From: Martyn White
Sent: 18 January 2019 12:24
To: Planning.Responses
Cc: Zac Denton
Subject: AB/135/18/HH & AB/136/18/L

AB/135/18/HH & AB/136/18/L

The application relates to an existing sun room which it is proposed to replace on a very similar basis. The sun room is located within the rear garden area of the property, and is attached to a single storey building. This building is located within the curtilage of a listed building, and is therefore curtilage listed. It is also located within the Arundel Conservation area.

PROPOSED PLAN & ELEVATIONS
OF CONSERVATORY

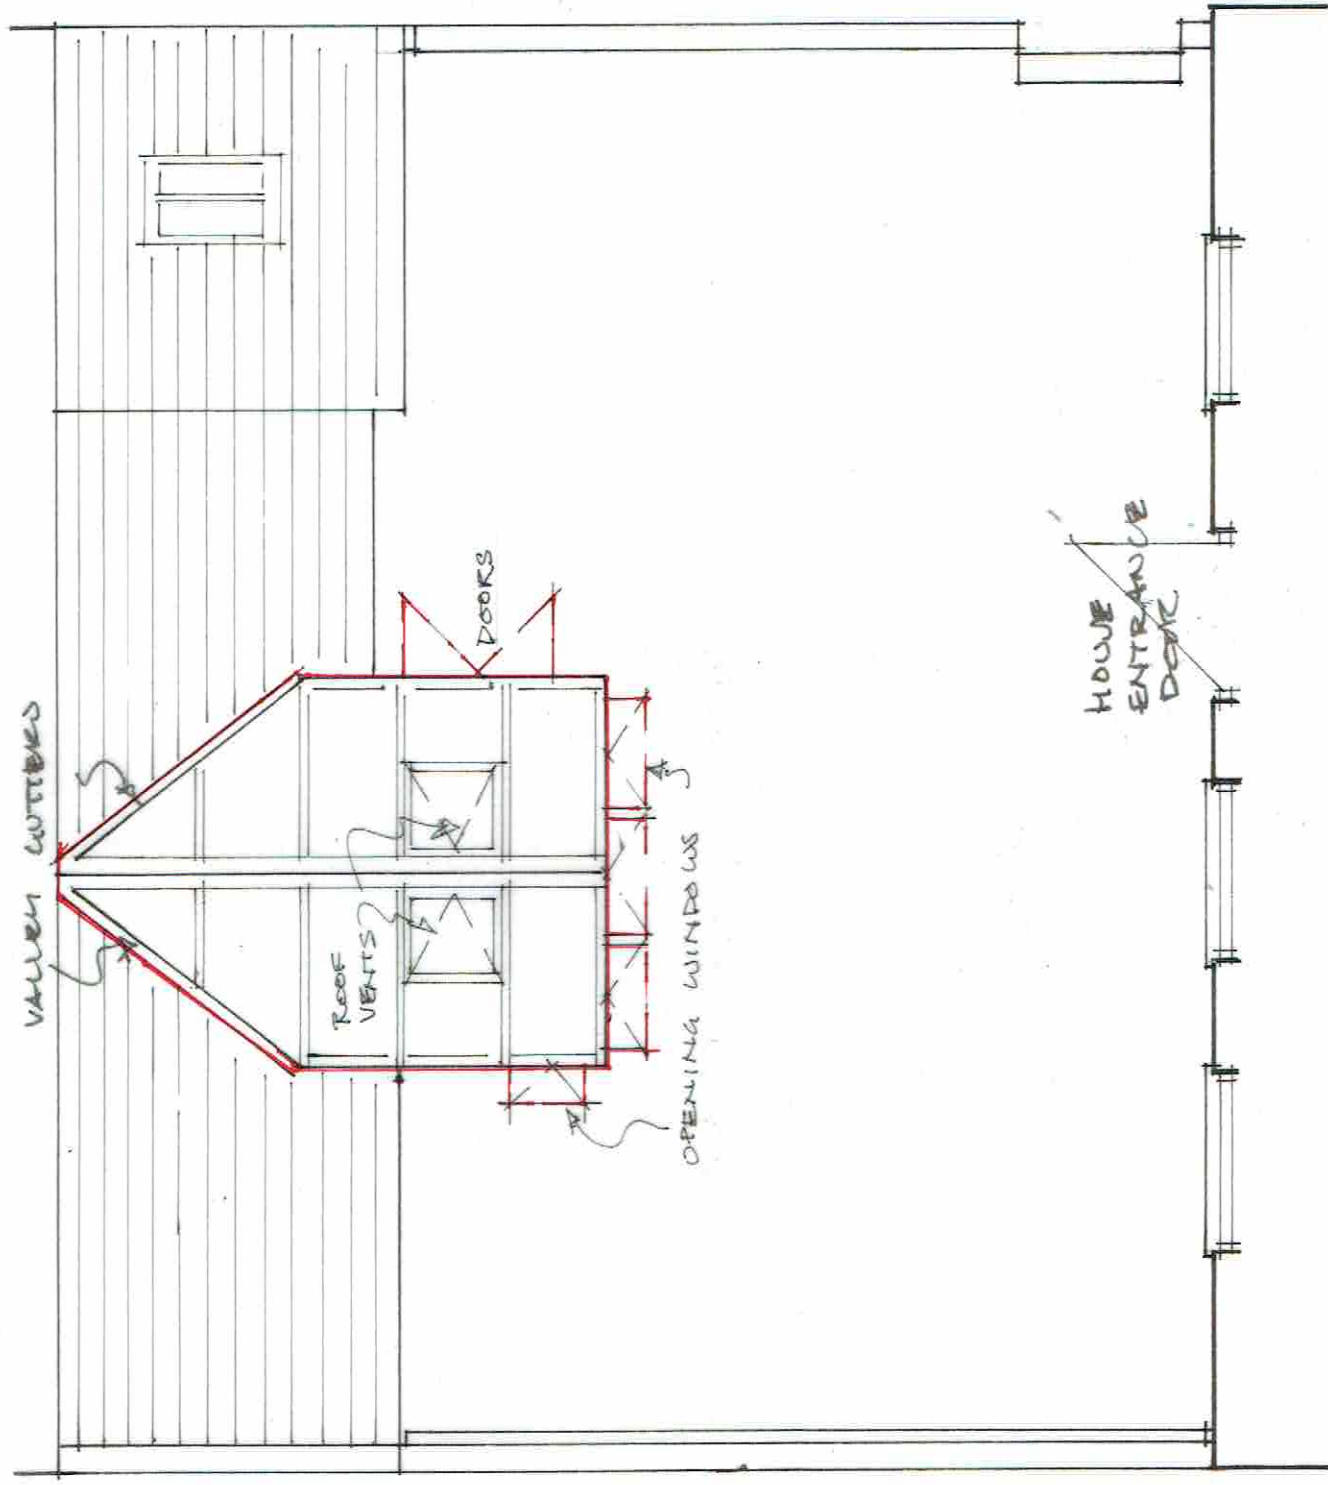
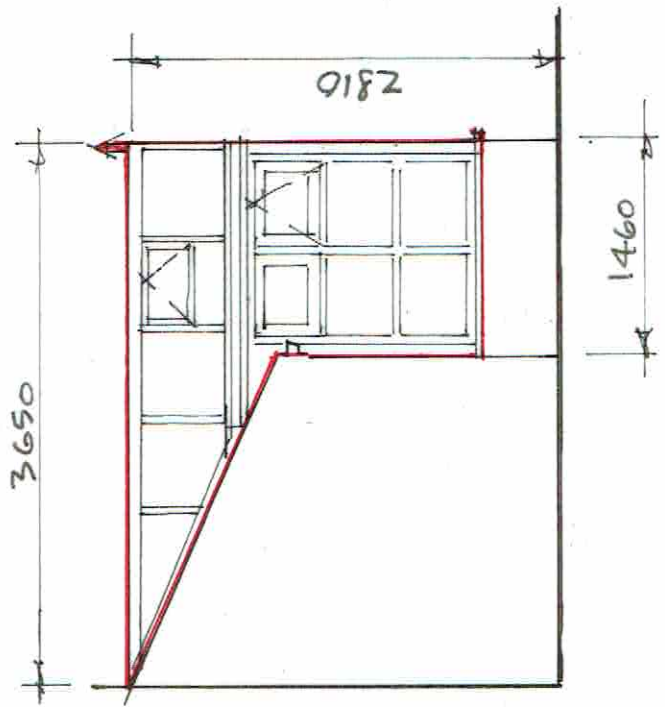
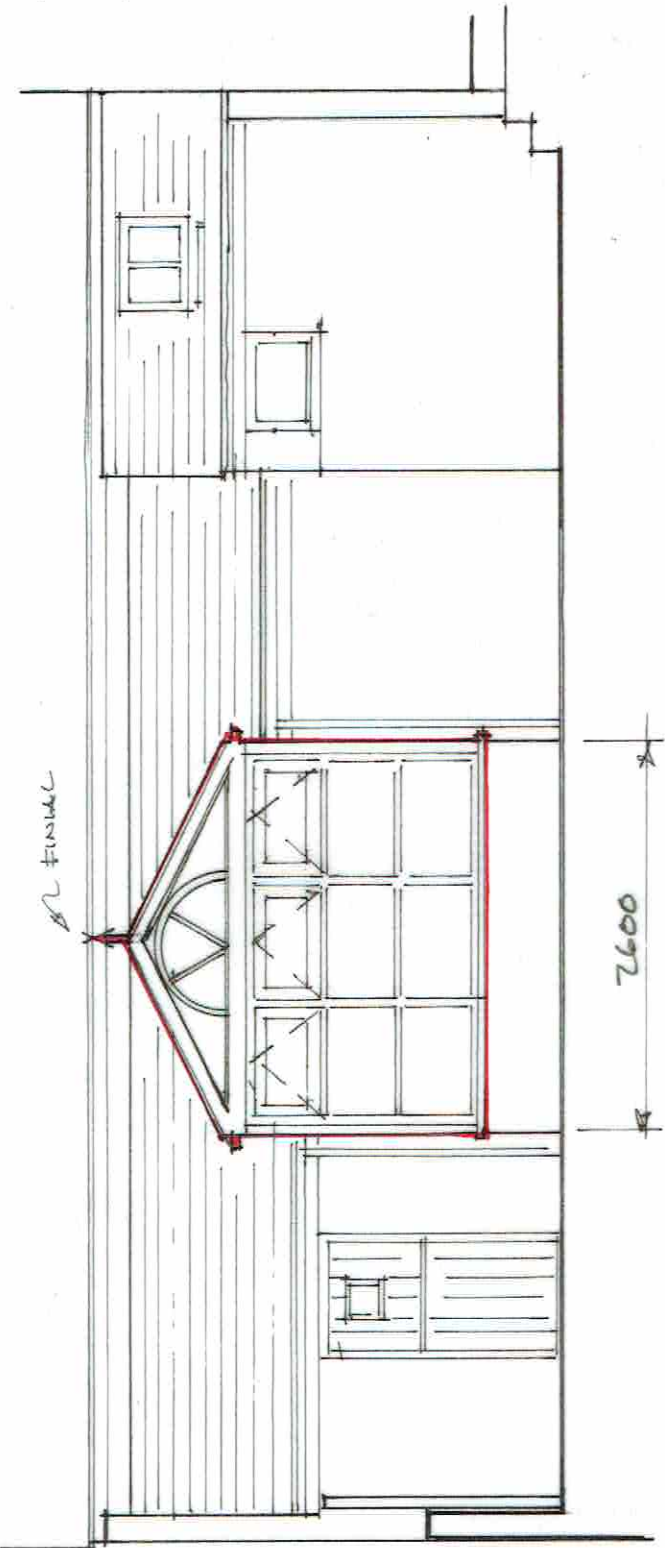
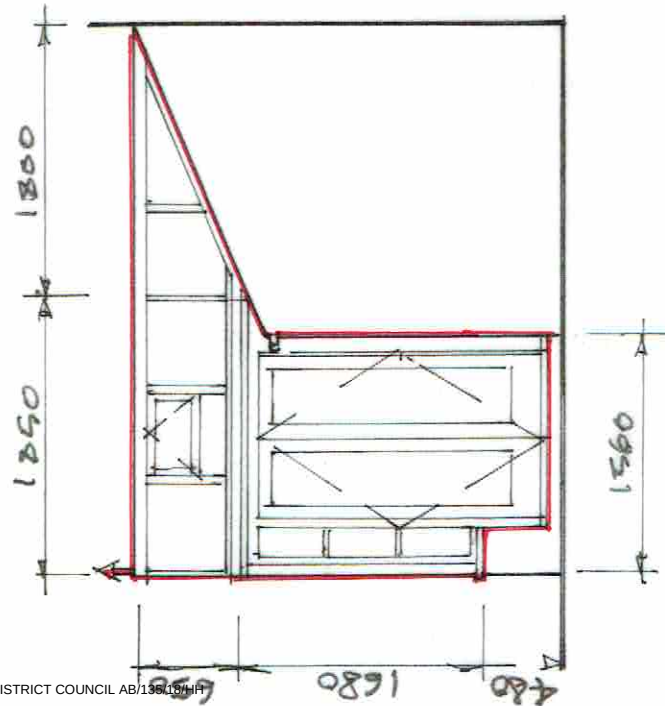
The single storey building is simple in character and constructed using traditional materials. It plays a subservient role to the main dwelling, and the proposal should ensure that this relationship continues. Essentially, as the proposal will replace an almost identical structure, there can be no concerns. However, the success of such a scheme will then depend upon the quality of the materials used and the design of the wooden structure/windows. Overall, the design is acceptable, although it would be preferred if the French doors replicated the existing design, such as the inclusion of glazing bars. Further, it is not clear if the units will be single or double glazed?

If minded to approve, you may wish to condition details of the joinery
